CITY OF ALBUQUERQUE

June 2, 2017

Re: Murphy Express
1358 Wyoming Blvd. NE and 1336 Wyoming Blvd. NE
Traffic Circulation Layout
Engineer's Stamp XX-XX-XX (J20D037)

TCL-1

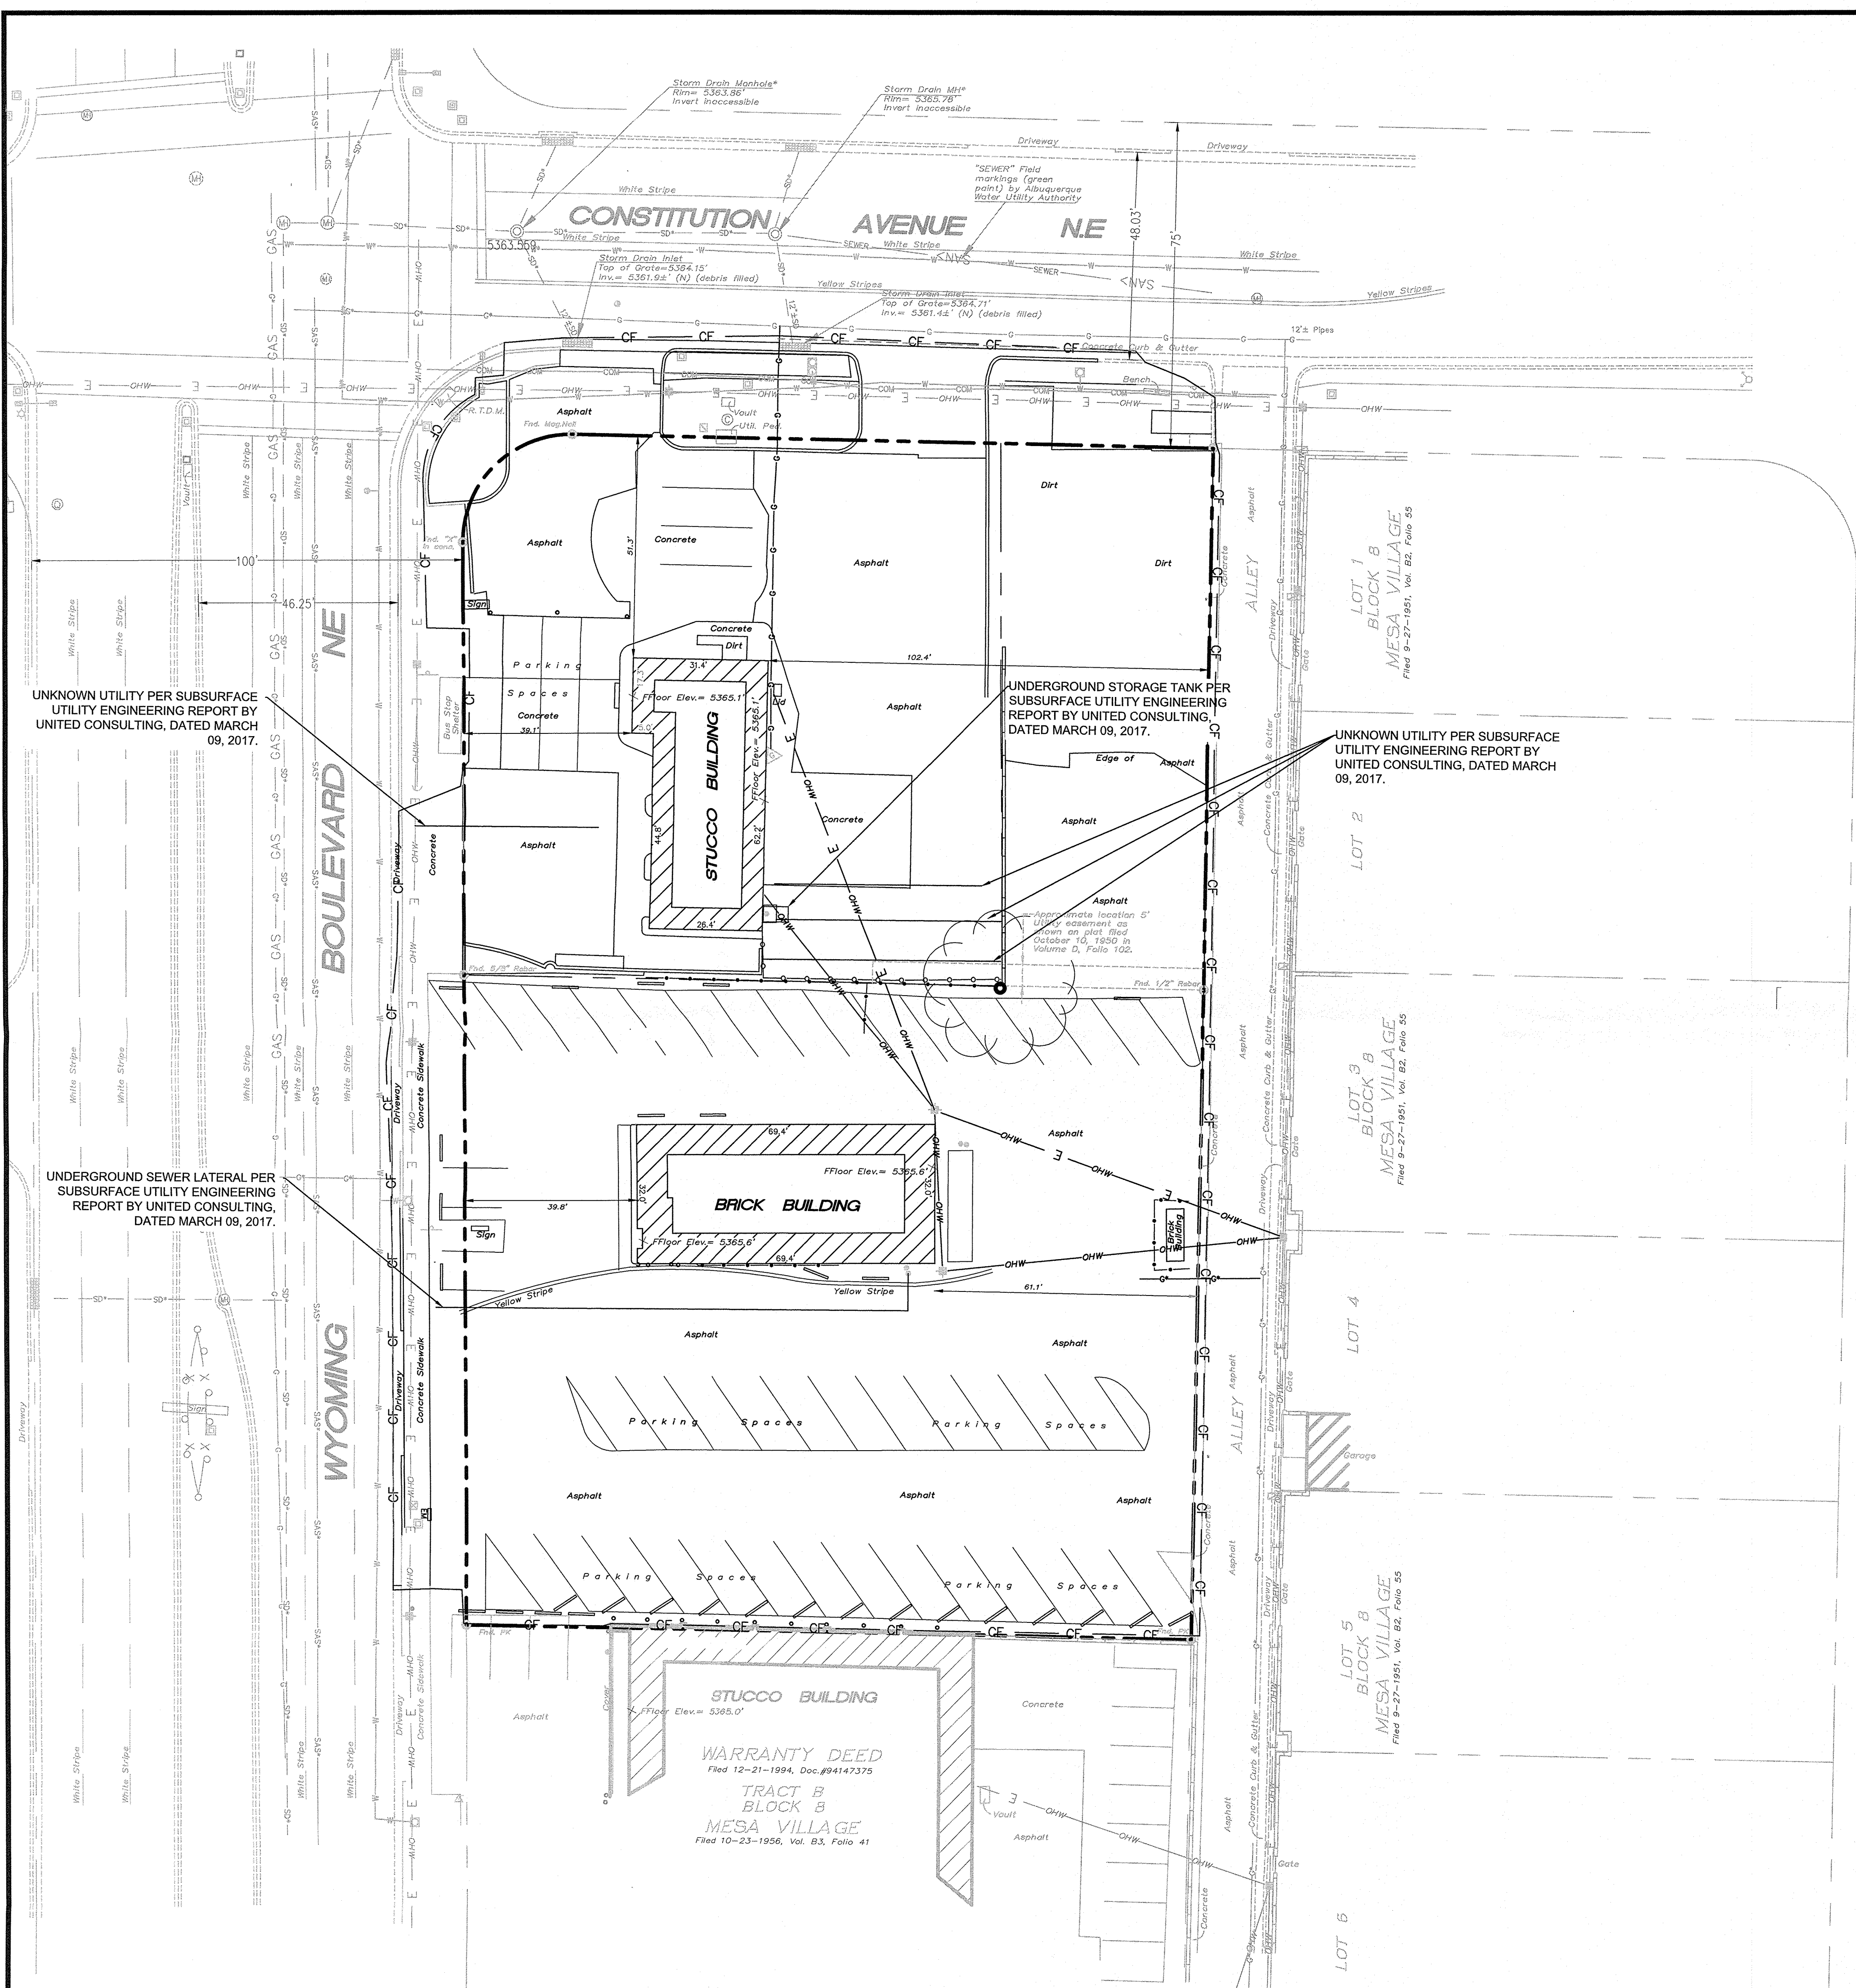
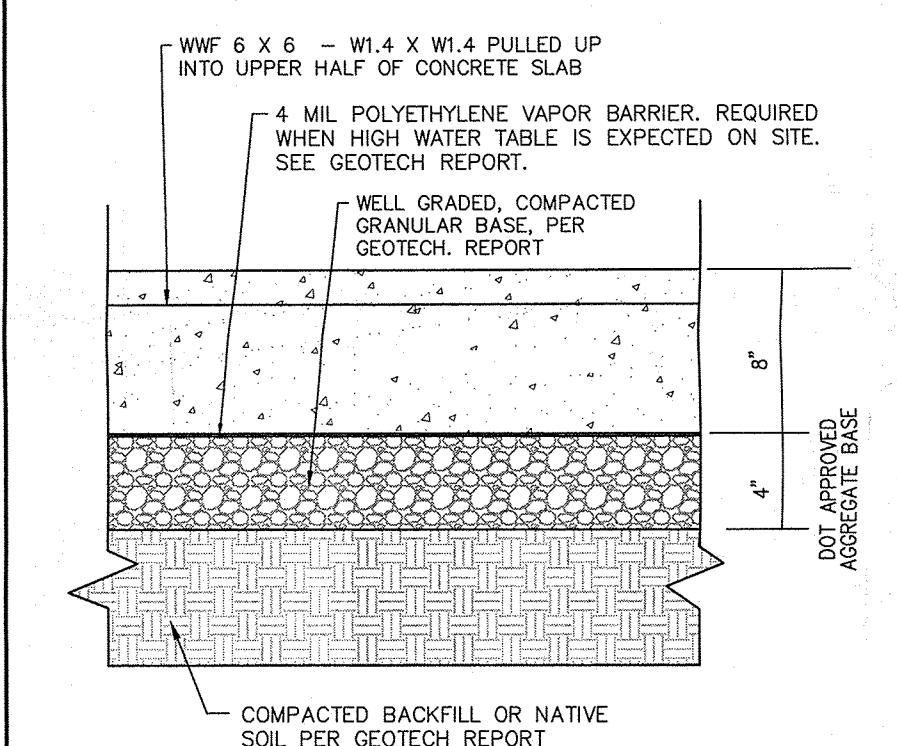
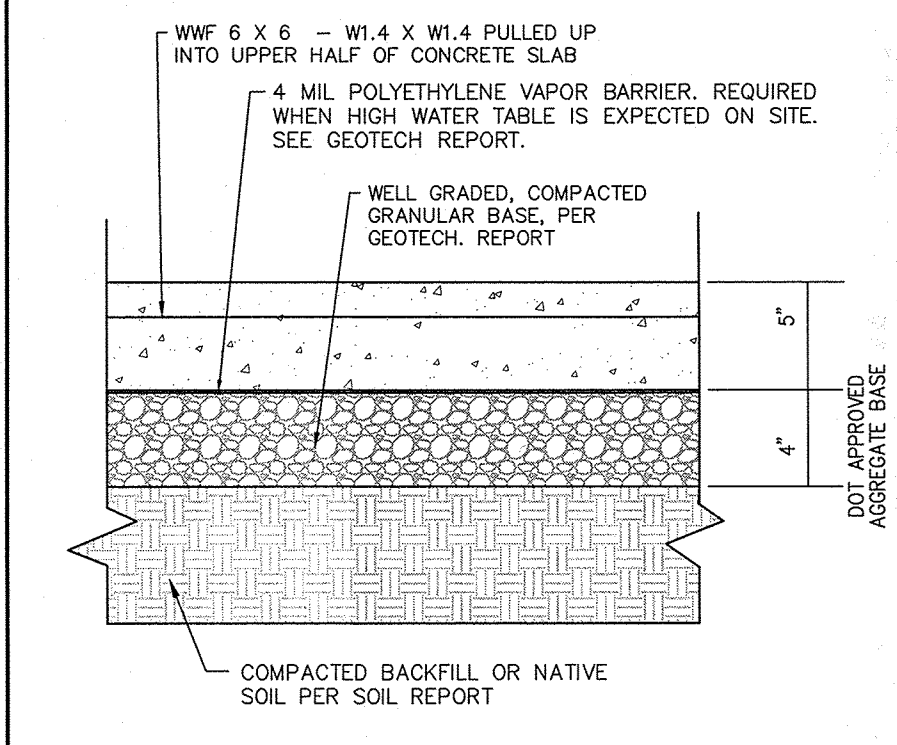
1. Identify streets widths (Wyoming and Constitution).
2. The ADA access aisles shall have the words **"NO PARKING"** in capital letters, each of which shall be at least one foot high and at least two inches wide, placed at the rear of the parking space so as to be close to where an adjacent vehicle's rear tire would be placed. (66-1-4.1.B NMSA 1978)
3. It is not apparent what type of pavement surface is being proposed. A hard driving surface will be required as part of this proposed project for parking area and drive aisles.
4. Unused curb cuts must be replaced with sidewalk and curb & gutter. A build note must be provided referring to the appropriate City Standard drawing.
5. Please indicate the Bike Rack and motorcycle sing on the plan.
